The Drovers Solar Farm

Statement of Common Ground (SoCG) with Environment Agency (Clean)

PINS reference: EN0110013

Document reference: APP/5.13.1 (Revision 1)

DRAWING TITLE:
Figure 12.15: Work No. 4 Maximum Potential Foundations and Groundwater Elevations

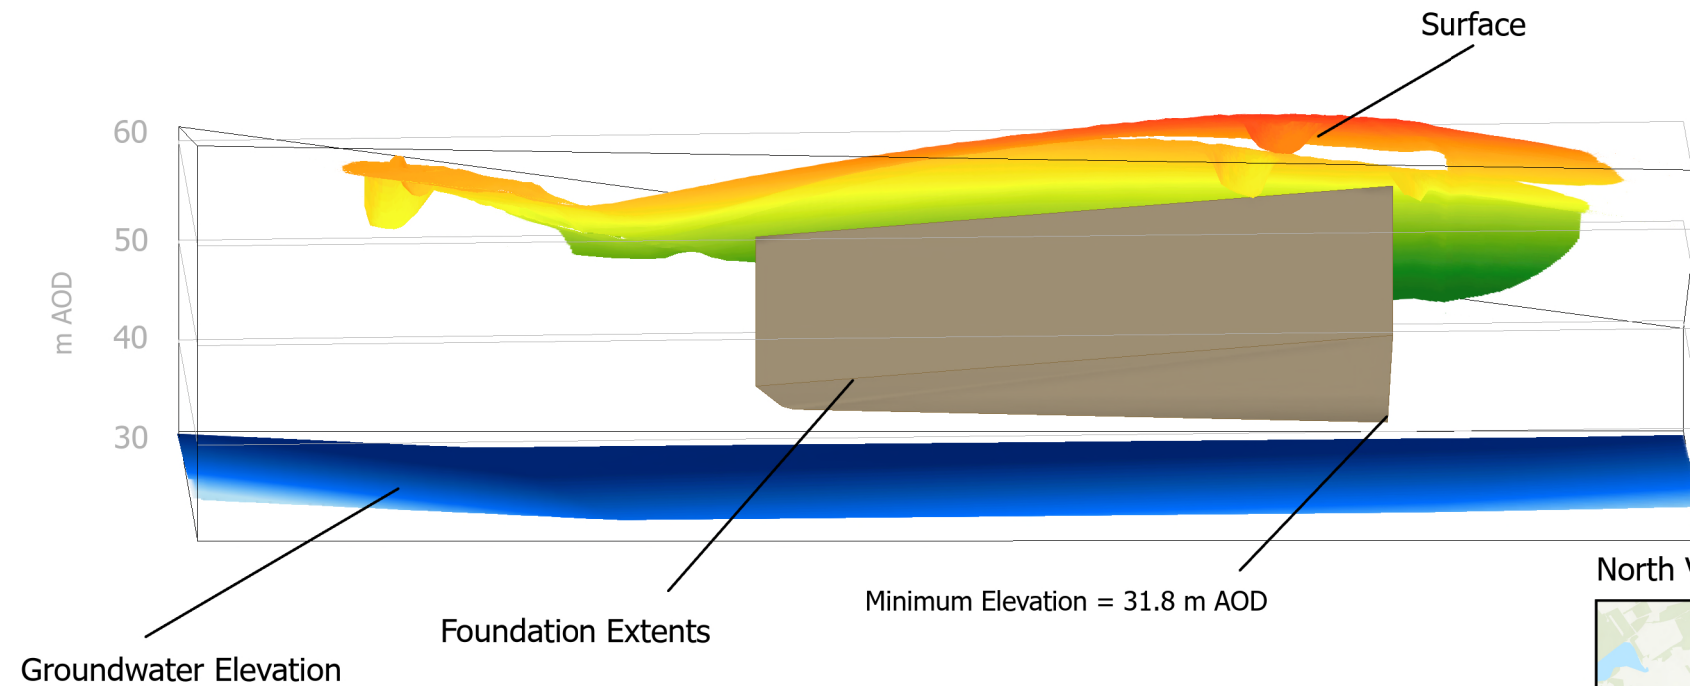
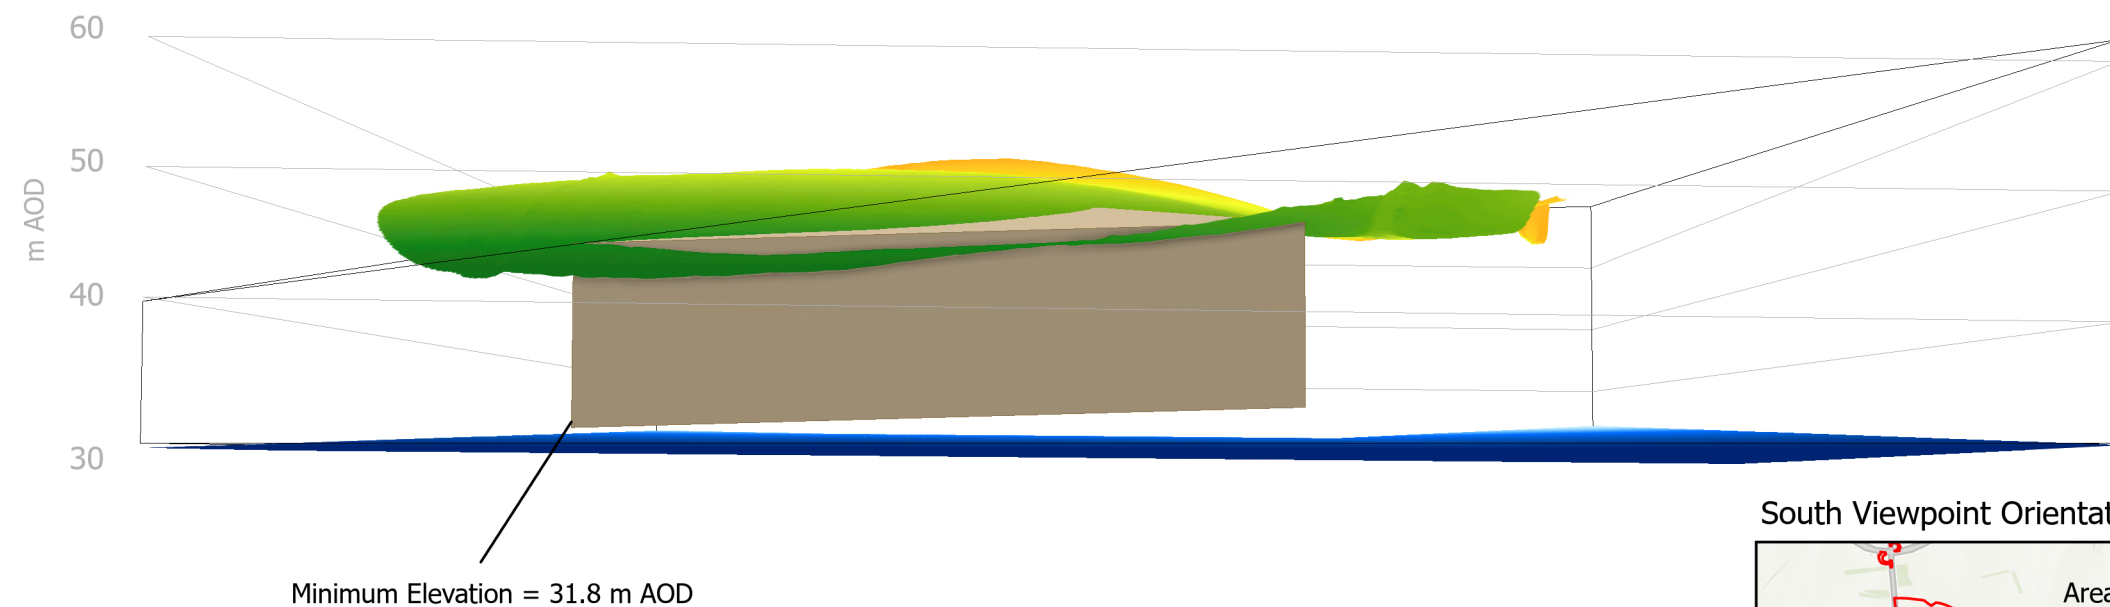
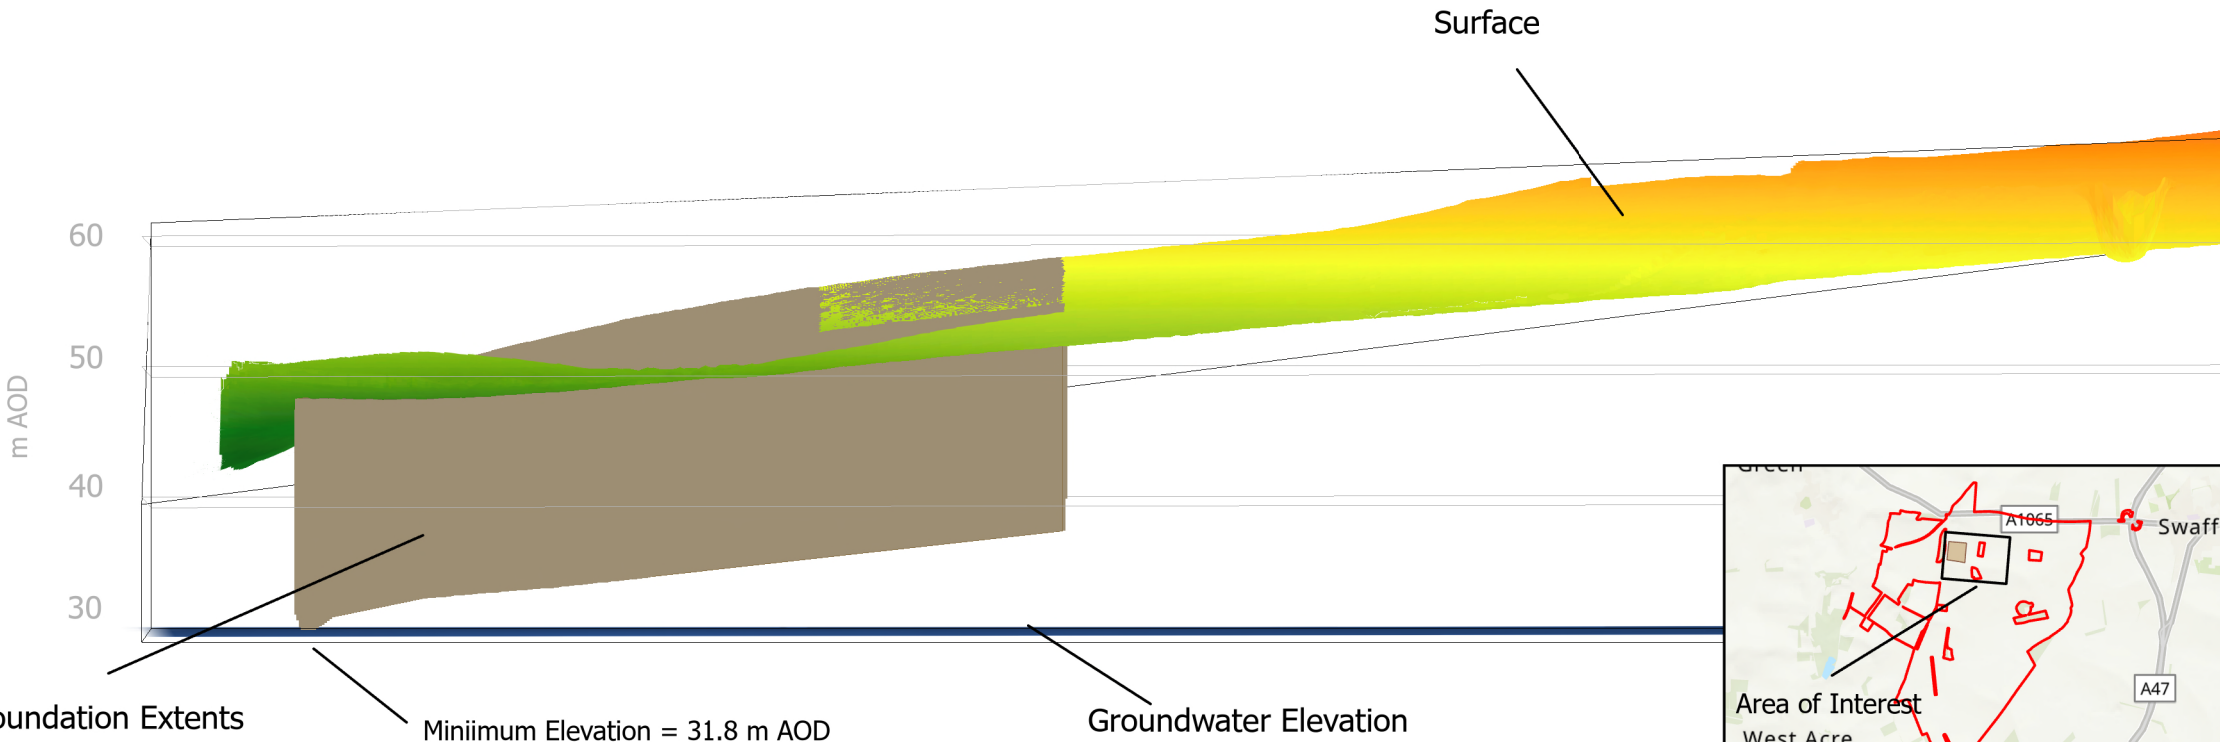
Reference	EA Issue Reference	Topic	Consultee's Position	Applicant's Position	Status
2-1	EA05	Maximum Foundation Extents	Figure 12.13 Work No.2 Piling Locations within CSA for Maximum Groundwater Level [APP-127] Figure 12.14 Work. No 3 Piling Locations within CSA for Maximum Groundwater Level [APP-128] Figure 12.15 Work No. 4 Piling Locations within CSA for Maximum Groundwater Level [APP-129] Figure 12.16 Maximum Foundation Extents for Minimum Groundwater Level [APP-130] Issue: Figures 12.13 to 12.16 do not clearly show the orientation of each 3D model view,	Figures 12.13 to 12.16 of ES Chapter 12: Water Resources [APP-061] were used to illustrate the maximum groundwater elevation surface across the Core Study Area and identify where proposed foundation depths could theoretically intercept shallow groundwater under worst-case conditions. The figures also demonstrate at a concept level where piling may be required depending on foundation design. The following changes have been made at Deadline 3 to aid the EA's interpretation: Addition of orientation labels or description	Medium

and the elevation of the maximum extent of foundations is not given. Impact: Difficulty in interpreting figures. Solution: Revise figures to more clearly define the area represented in the drawings, including view orientation, and the maximum foundations extent should be shaded to show elevation values. The model should be updated to inform detailed foundation design, based on site specific survey and monitoring data. Additional Comments: Use of inconsistent terminology may also result in confusion. Figures 12.13 to 12.15 are titled to show the anticipated extent of piling in comparison with the maximum groundwater level. In the context of the data presented, the maximum groundwater level in mAOD represents the shallowest extent and therefore worst-case condition for groundwater. For clarity the report should preferably refer to groundwater 'elevation' (in mAOD) as is represented within the figures rather than 'level', which could be misinterpreted as relative to ground level rather than Ordnance Datum. Figure 12.16 shows the minimum (i.e. deepest) groundwater elevation (i.e. best case) in relation to anticipated piling depth. Although this is useful information, this could potentially be misinterpreted by the reader as presenting a combined overview of the	- Elevation shading to show mAOD values for the maximum groundwater elevation surface and foundation extent surface - Highlight areas where foundations intersect or exceed groundwater elevation surfaces; and - Figures and text refer to groundwater elevation (mAOD) rather than groundwater level to increase clarity between absolute elevation and depth below ground. The Applicant agrees that the conceptual model present is not the final tool for foundation design, but rather to provide a screening-level assessment of groundwater conditions and to identify areas needing piled or shallow foundations and will be aligned with EA regional groundwater understanding (NEAC model). The Design Principles, Parameters Commitments [APP/5.8.3] have been updated at deadline 2 to commit to foundations not directly interacting with groundwater.
